Recommendation Report for Planning Permission

REF NO: FG/34/20/PL

LOCATION: 74-78 Ferring
Ferring
BN12 5JP

PROPOSAL: Replacement of an ATM.

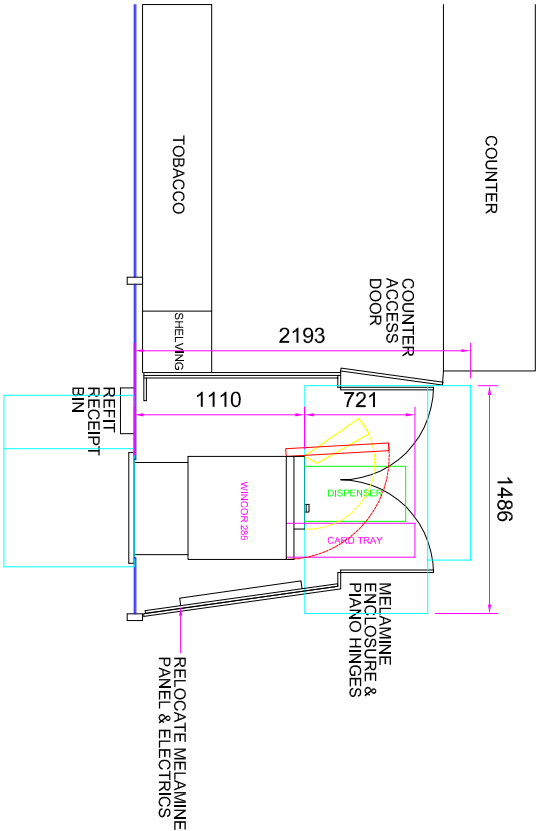
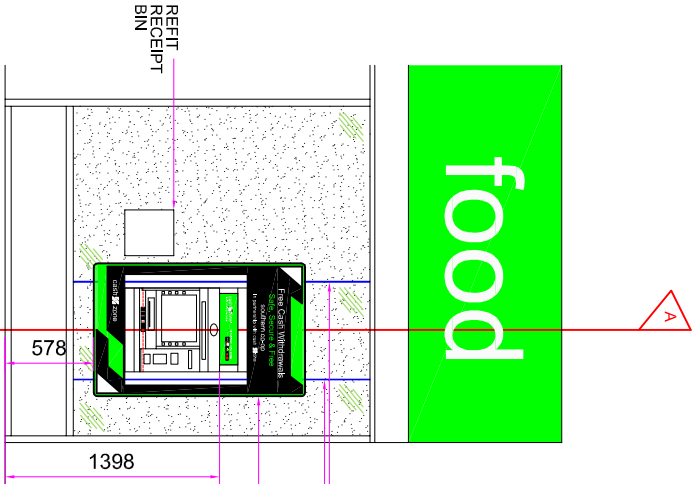
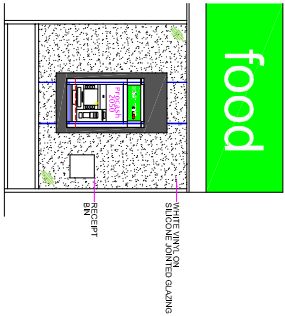
DESCRIPTION OF APPLICATION	Almost identical replacement moving the current cash machine to the right of the glazed panel rather than in the centre as existing.
SITE AREA	N/a.
SITE CHARACTERISTICS	A village centre convenience store
CHARACTER OF LOCALITY	A retail village centre.
None relevant

The design of the cash till machine is acceptable and would have no material additional impact to the existing appearance of the elevation giving the siting of an existing till machine. The proposal is considered to accord with policies D DM1 and D DM4 of the Arun Local Plan.

The cash till machine is located on the opposite side of the road to the nearest residential properties and it is not considered that it would have anymore impact on residential amenity than the existing machine in accordance with policies D DM1 and D DM4 of the Arun Local Plan.
